MAWS FARM IS NOT A SUITABLE LOCATION FOR A “HIGHLY VULNERABLE DEVELOPMENT”

**DART + WEST ELECTRIFIED RAILWAY ORDER 2022
Ref ABP-314232-22**

Module F: Landowner and Observer Submissions Zone F: Maynooth Station to Depot

Objection to the Proposed Siting of the EMU Depot and the associated Compulsory Purchase Order of Lands at Maws Farm, Maynooth West, Co. Kildare

Figure 2.10: Location of Unclassified Barrow Site within Proposed Maws Depot Lands (Source: Google Maps, annotated by Tom Phillips + Associates, October 2022.)

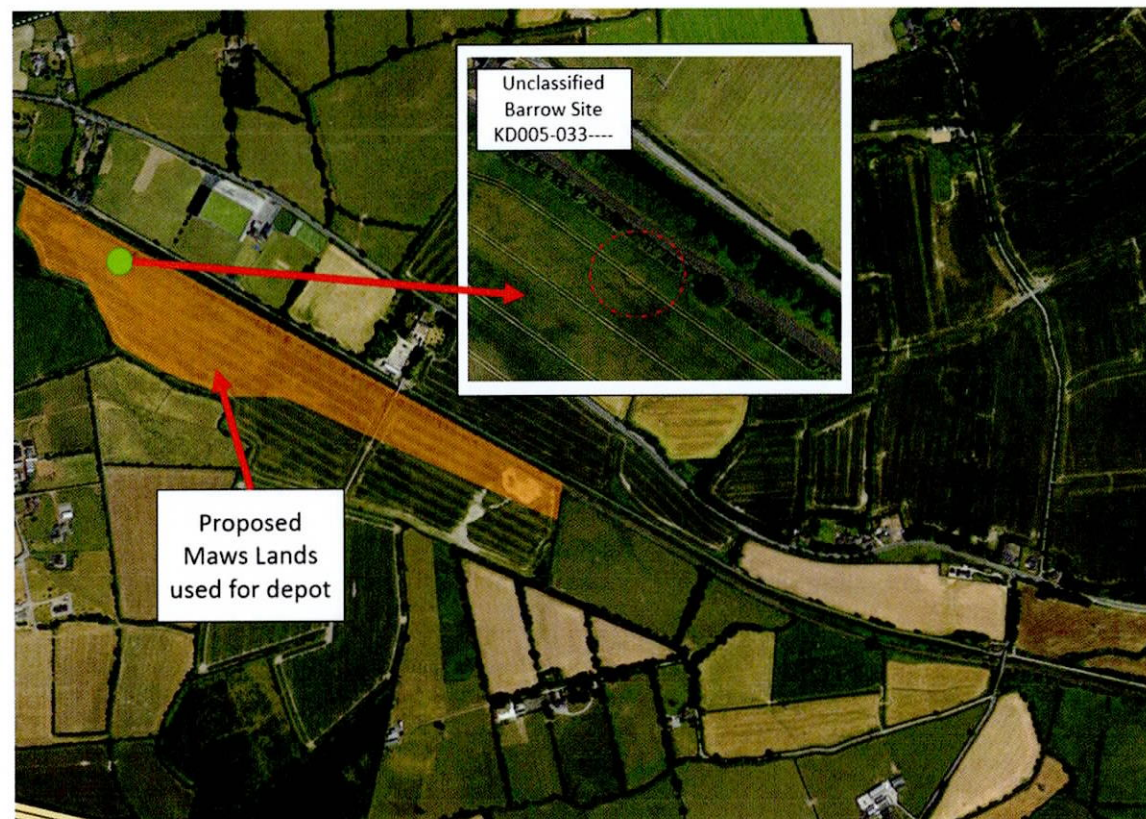
Archaeological Remains – Bronze Age

Figure 2.11: Extract from DART + West EIAR Vol 4 App A20.4 Geophysical Survey Report (Source: EIAR Vol 4 App A20.4 Geophysical Survey Report, March 2022.)

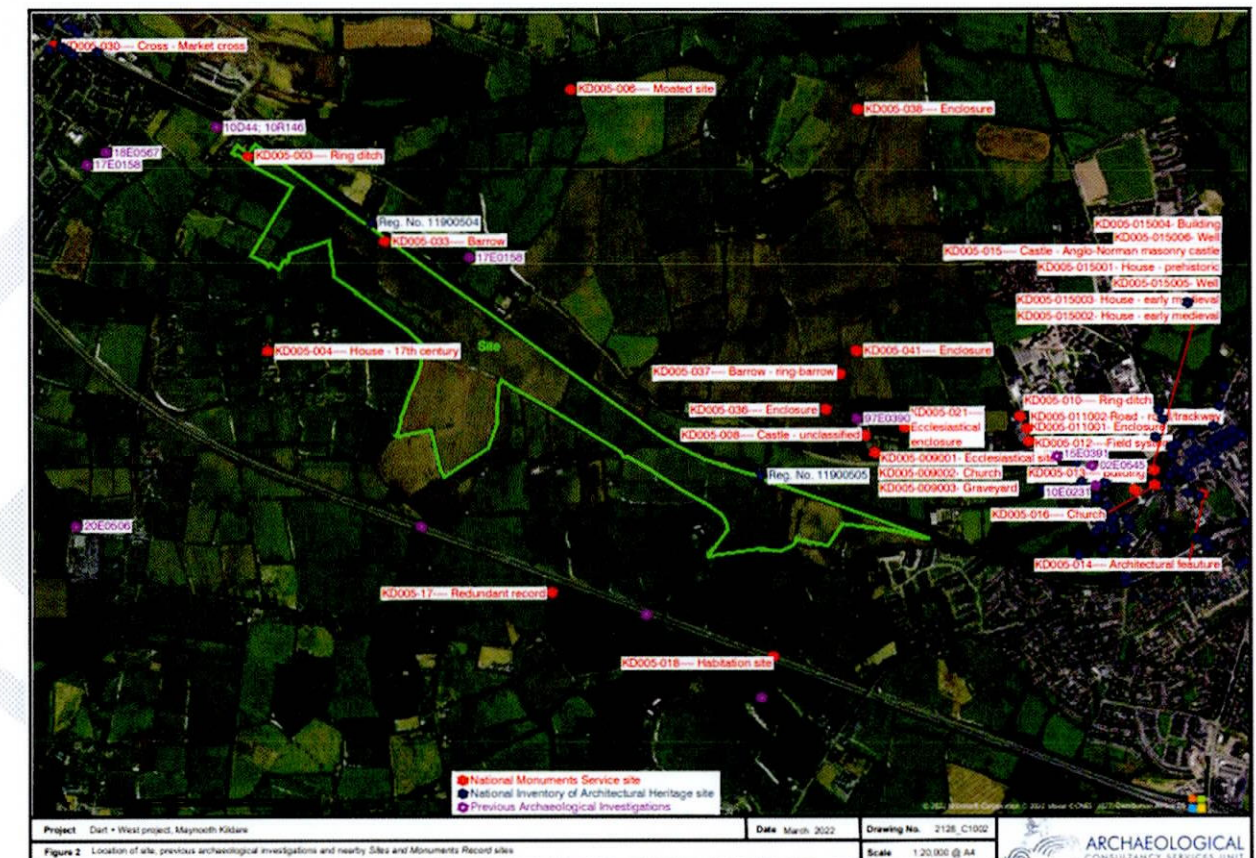
Where not to build: Archaeological sensitivity
